Waste Management Facility, Botany

Integrated Water Management Strategy

1.2 RESPONSE TO SUBMISSIONS COMMENTS

A response to this submission was provided by Bayside Council (their ref: SSD-2024/10) dated 09/09/2024 – and the response to their civil engineering queries is summarised below (note flood and landscape related queries are responded to in other respective reports):

Project: HALE STREET, BOTANY		Drawing Title: STORMWATER MUSIC CATCHMENT PLAN	
Client: COOMBS PROPERTY GROUP		Drawn By: IS	Checked By: BW
Project Number: 15146		Level: 00	Drawn Scale: 1:250 @ A1
Zone: CJA		File Type: DWG	Revision: A
Date of first issue: 28.08.25		Number: 1120	Revision: A

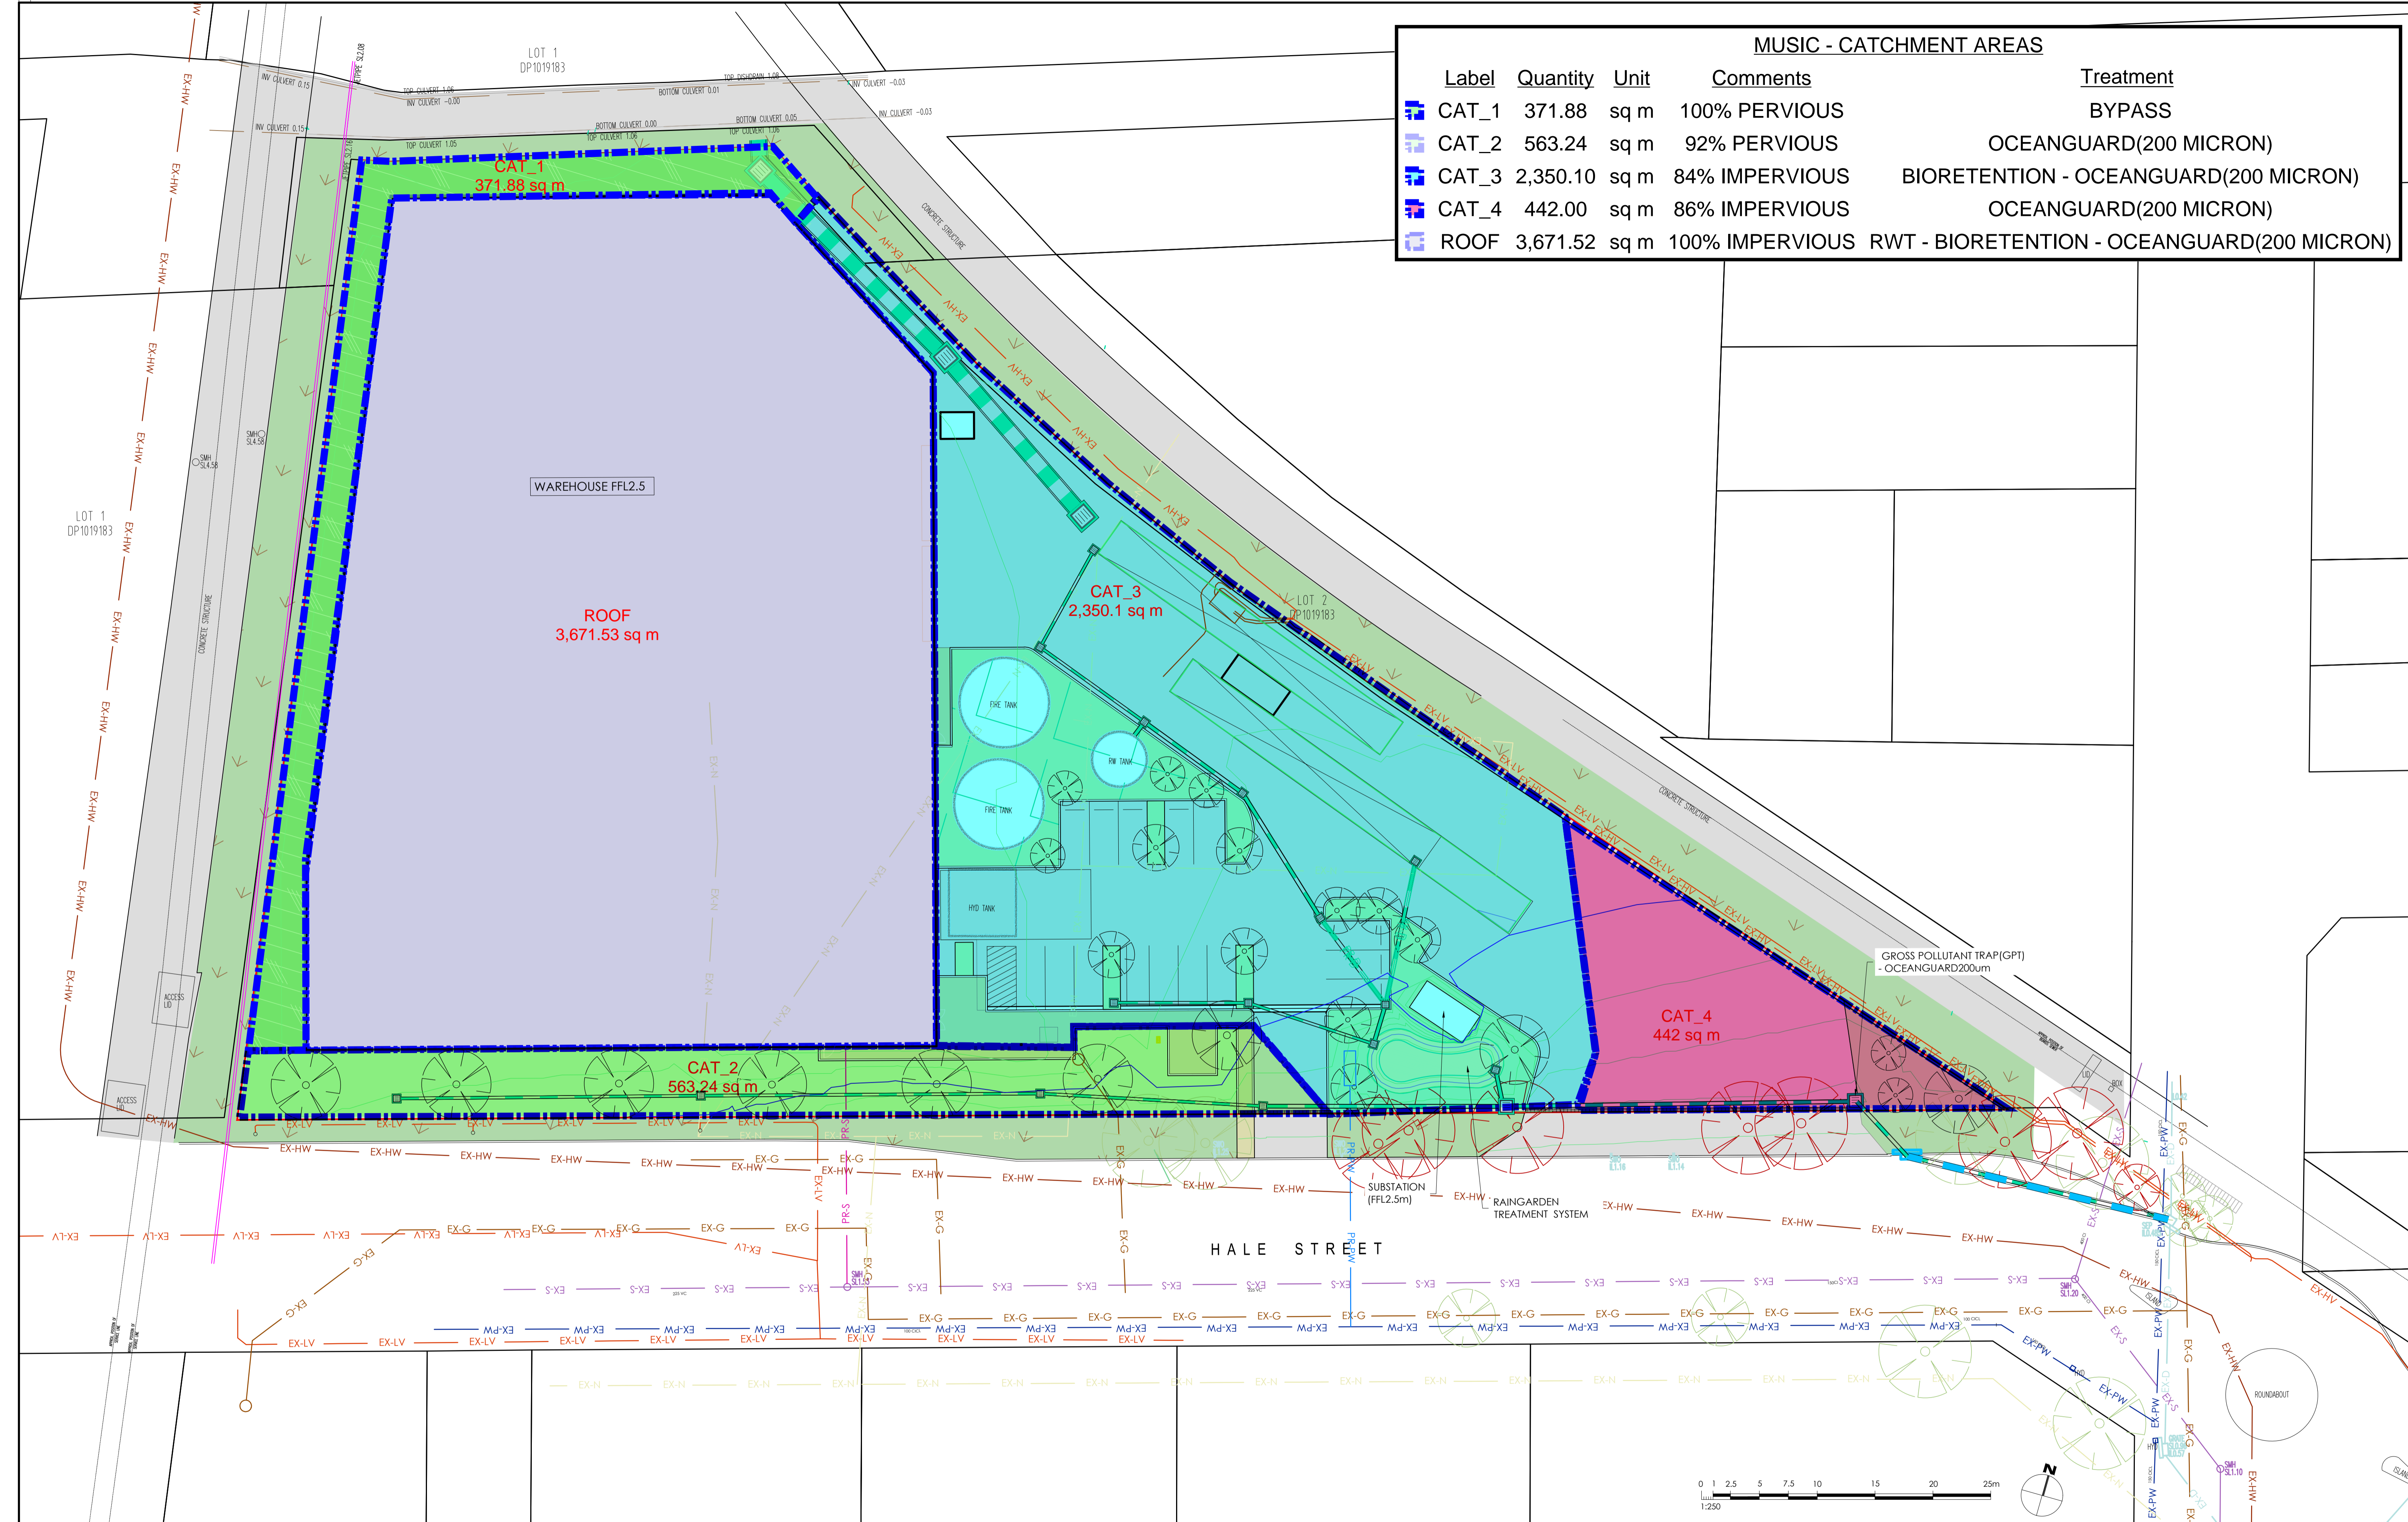
<p>Furthermore, figure 5 of this report cannot be assessed as it does not include the areas of each catchment and is not supplemented by stormwater plans verifying the catchment areas and demonstrating the treatment train is feasible.</p>	<p>Refer to Table 4 on Section 5.8 and Catchment area plan in Appendix C</p>	<p>Section 5.8: Table 3; Appendix C</p>
<p>The parameters of the bioretention system in the MUSIC model shall be shown. The bioretention system appears to be overperforming and it’s not clear how the site will effectively capture gross pollutants from impervious areas. Furthermore, it needs to be detailed how this system will work given the substation and trees proposed in this area.</p>	<p>This is included in the soft copy of the MUSIC file provided for council review.</p>	<p>Attached .sqz file</p>
<p>A soft copy of the amended MUSIC modelling shall be provided.</p>	<p>As above</p>	<p>Attached .sqz file</p>

Bayside Council Comments	Proponent Response	Location Addressed
<p>A WSUD catchment plan highlighting the impervious and pervious areas for water quality treatment including areas which bypass the treatment system should be provided. The WSUD catchment plan shall be aligned with the MUSIC modelling and shall be scaled with the architectural plan in the background. The MUSIC modelling shall be consistent with the WSUD catchment plan.</p>	<p>Refer to Table 4 on Section 5.8 and Catchment area plan in Appendix C</p>	<p>Section 5.8: Table 4; Appendix C; Attached .sqz file</p>
<p>The fuel tank must be bunded, located under a roof structure and drained directly to the Sydney water sewer. No run-off from the fuel dispensing area is to be directed to the stormwater system.</p>	<p>This is shown on the architectural drawings and reflected on our updated civil concept plan.</p>	<p>Appendix B</p>
<p>The plans propose an extension of Council’s Hale Street drainage infrastructure. A surveyor must be engaged to determine all relevant levels (e.g., the invert levels) of this infrastructure.</p>	<p>This will be done and submitted with detail design</p>

RG.01
RAINGARDEN - TYPICAL SECTION
SCALE 1:25

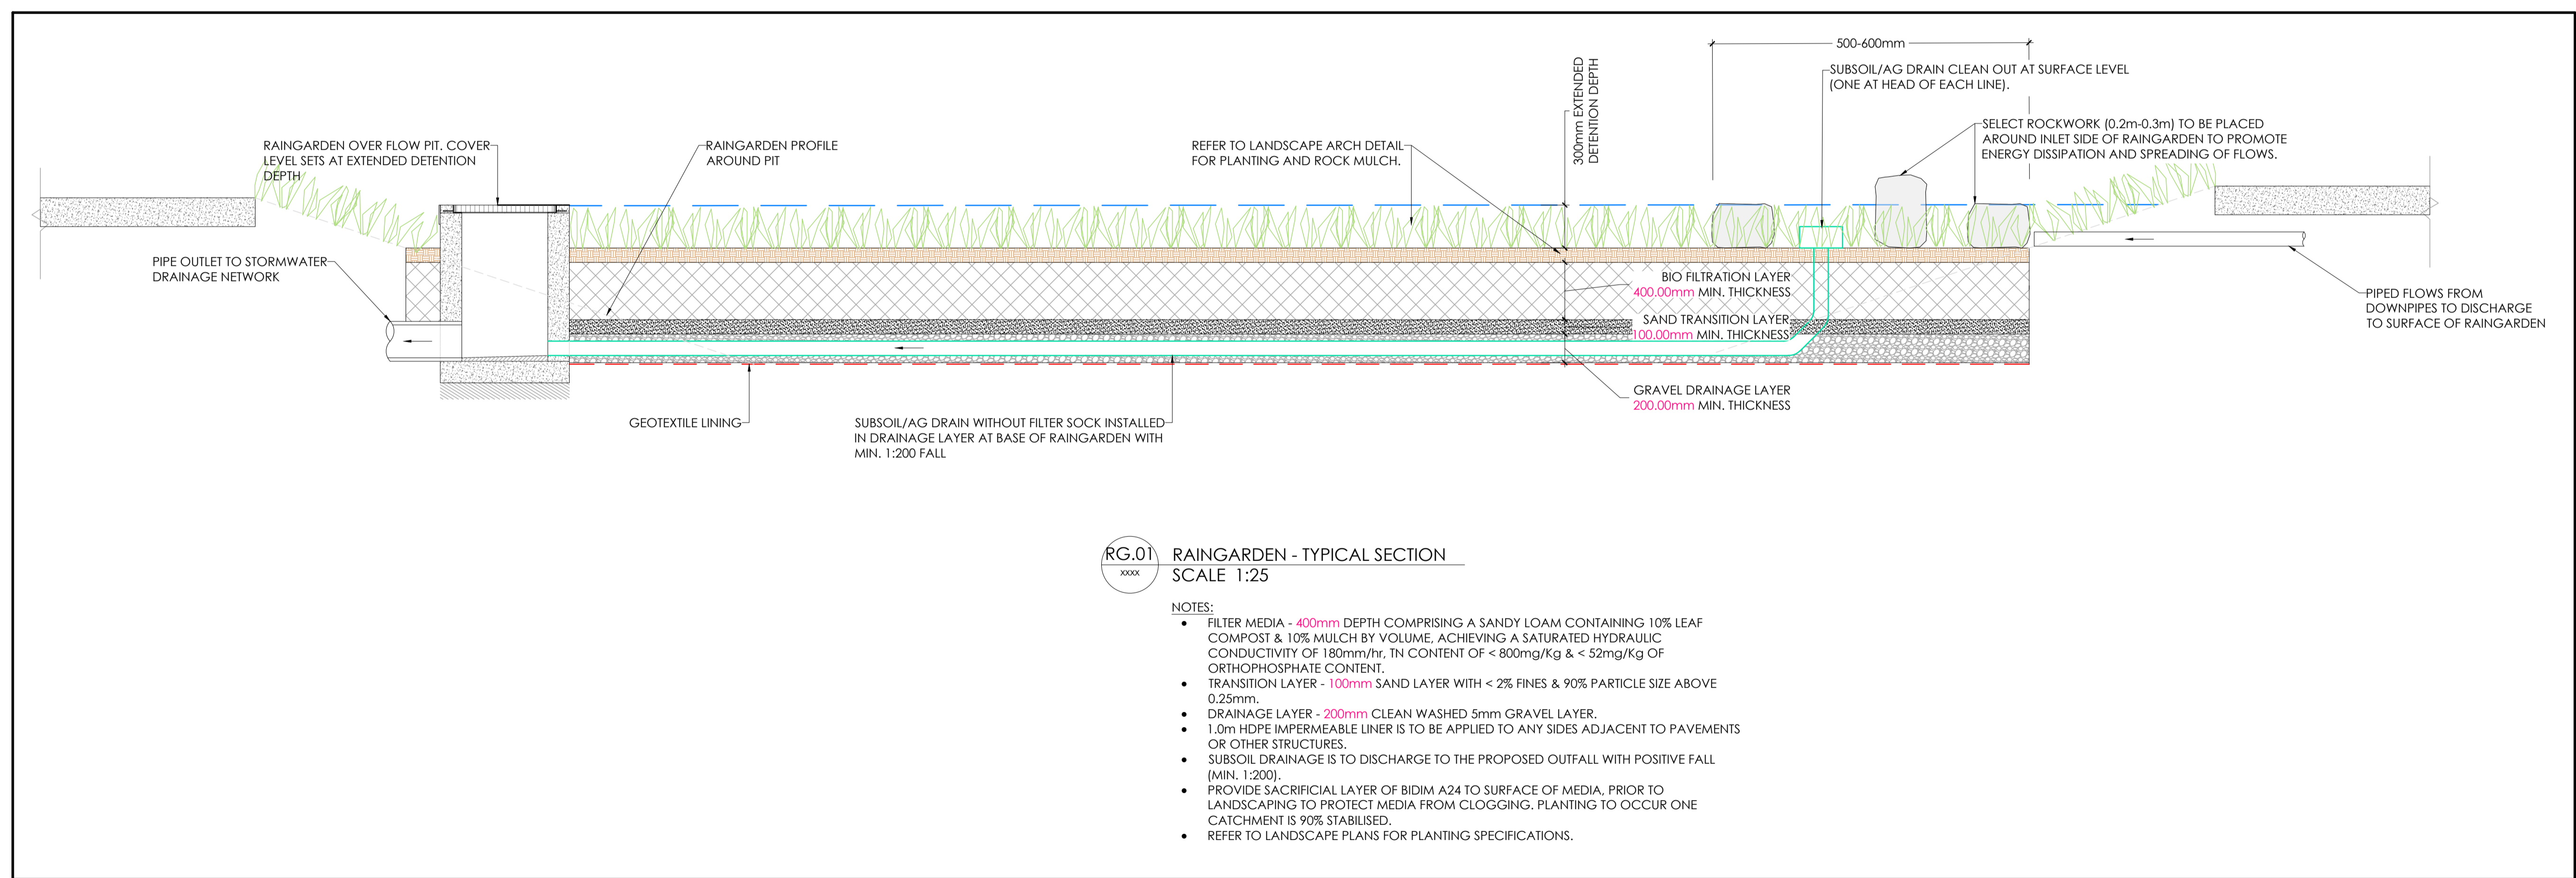
Bayside Council Comments	Proponent Response	Location Addressed
<p>j) The following issues have been identified in the plan submitted:</p> <p>i. No sections or design details of the raingarden have been provided for review. This is particularly important as the raingarden appears to be overperforming in its impact on water quality treatment.</p> <p>ii. Design levels and pipe/culvert sizes for the drainage systems were not sufficiently submitted.</p> <p>iii. Proposed pipe sizes are not confirmed.</p> <p>iv. Trapped low points are created in the northern corner of the site with no drainage provided</p> <p>v. Insufficient details have been provided for the drainage works in the road reserve that the development is relying on for discharge. The previous submission matter requiring additional survey data has not been addressed.</p> <p>vi. No manufacturer specifications for the Stormwater Quality Improvement Devices are provided in the drawings. Hence the MUSIC modelling cannot be confirmed.</p> <p>vii. No specifications of drainage elements such as pits including standard details are shown on the plans. "</p>	<p>i. Refer to dwg C-8001 showing details of raingarden.</p> <p>ii. Refer to dwg C-1100 for design levels, and dwg C-1110 and C6001 for drainage system</p> <p>iii. Refer to dwg C-1110 for pipe sizes</p> <p>iv. Refer to dwg C-1100 for design levels and falls. There will be no trapped low points created in the northern corner of the site.</p> <p>v. Refer to dwg C-1110 for drainage system. The updated survey drawing is attached in Appendix B.</p> <p>vi. Refer to dwg C-1110 drainage WSUD system. The OceanGuard 200micron GPT manufacturer is Ocean Protect.</p> <p>vii. Refer to dwg C-8000 for stormwater standard details</p>	<p>Appendix C – Civil Drawings as standalone package of plans, and also included in this report as appendix</p>
